I would like to comment on:

1/ AIL Route

2/ Church Hill, Saxlingham Nethergate

Figure 11.8: Likely and Suitable Routes to the Scheme

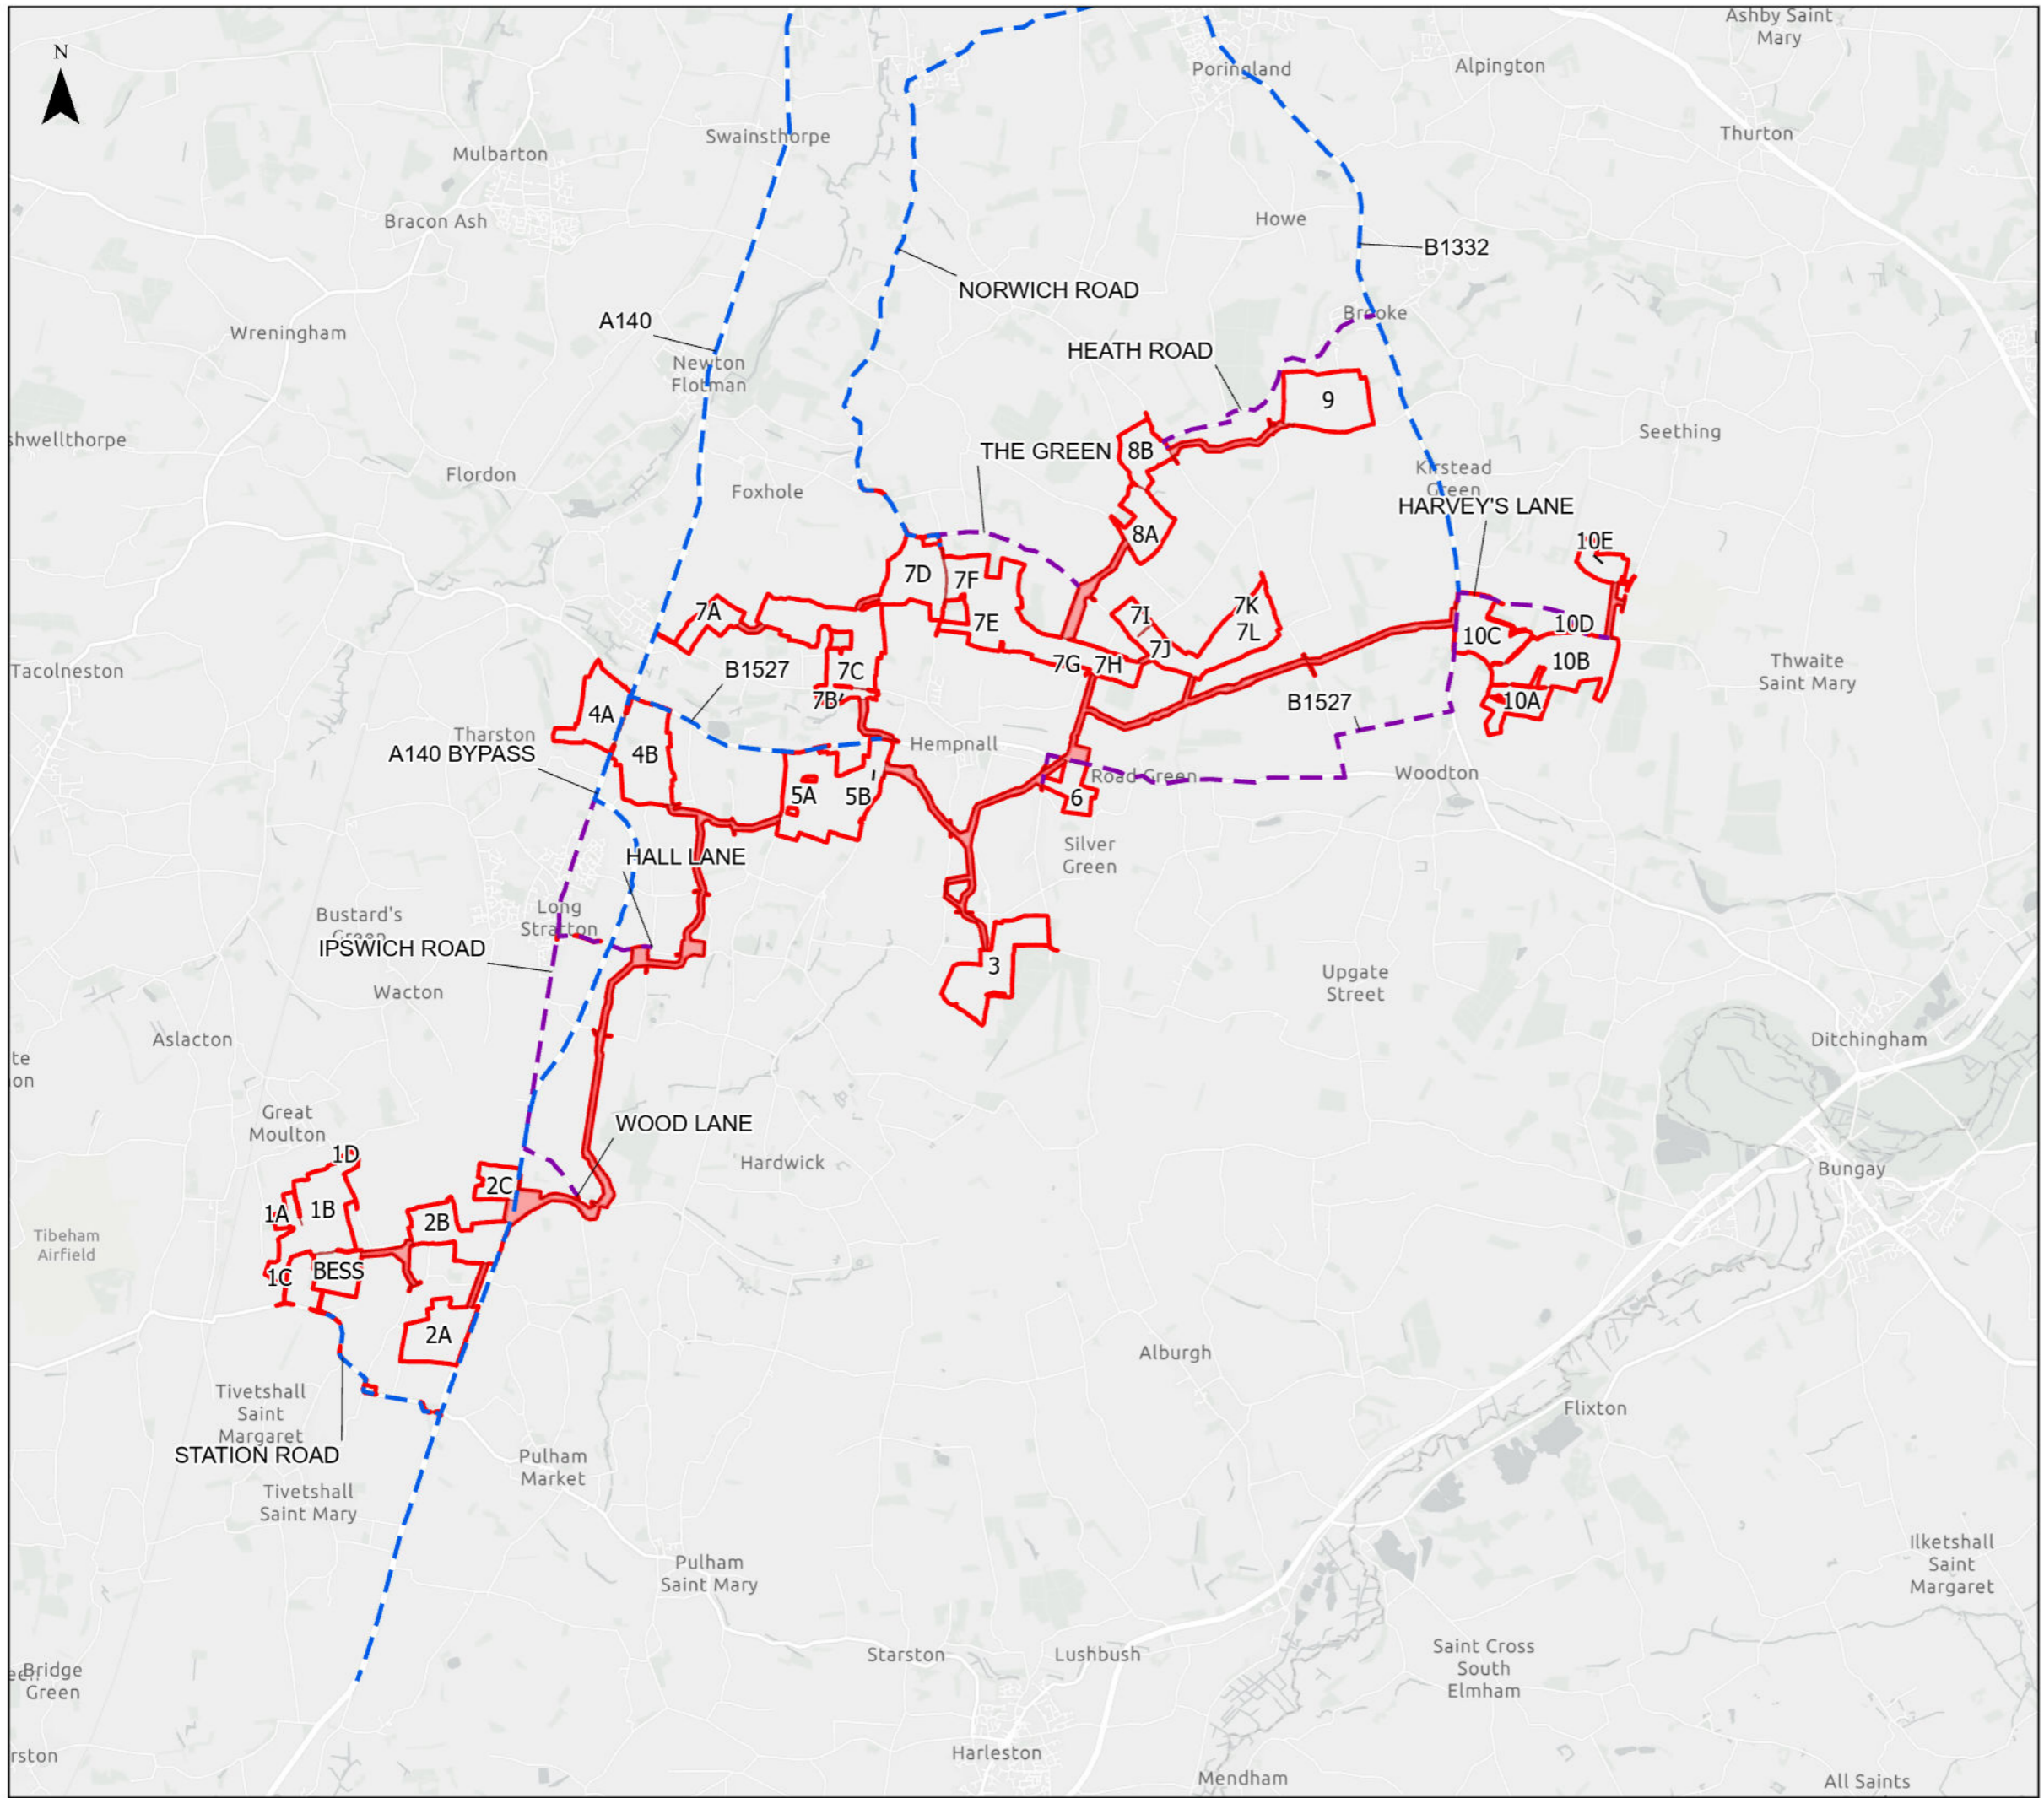
In October 2025 we were made aware by Targeted Consultation that East Pye's plans had changed and that it was now proposed that AIL vehicles carrying a transformer, and others carrying cable drums would be travelling from the 'Railway' roundabout in Poringland, down to Stoke Holy Cross, turning left and proceeding to and through Saxlingham Nethergate towards land parcels on site 7.

It is impossible to stress enough the unsuitability of the replacement route, which again feels as if it has been selected from a desktop study only, and I would **STRONGLY RECOMMEND** that Inspectors find time to travel along the full length of it, particularly from Stoke Holy Cross southwards as this is the only way to experience the winding and up and down nature of the route and the closeness of roadside ditches and trees and hedgerows, some on very steeply banked sides. Less obvious, but marked by occasional railing or kerbing, are a number of drainage culverts crossing under the road.

We are told that the largest of the AIL vehicles will be 4.86m wide, 40-45m long and 4.8- 5.2m high with a minimum 30m swept path radius. The only way they would be able to navigate this route would be by the extensive and irreversible removal of native hedgerows, verges and possibly trees, disturbing habitats, risking damage to delicate interlinked field drainage systems and blocking a well-used road while this devastating work was being carried out.

In addition, the route goes through several stretches of on-road parking, including Stoke Road in Poringland, Poringland Road in Upper Stoke and Long Lane in Stoke Holy Cross as well as along The Street in Saxlingham Nethergate.

There are also a number of 'pinch points', not least on Norwich Road in Stoke Holy Cross just before reaching the church at the top of the hill, which narrows to the extent that it is often necessary when heading to Norwich to drive onto the pavement to avoid large vehicles coming the other way. Any necessary widening will require the removal of hedging and trees owned by adjacent home owners. It is not obvious that the owners (or the Parish Council) have been consulted on this.

Once in Saxlingham Nethergate the road forms a bridge over a stream close to the junctions with Cargate Lane and Shotesham Lane. It is not clear whether or not this has been surveyed for its ability to bear AIL vehicles.
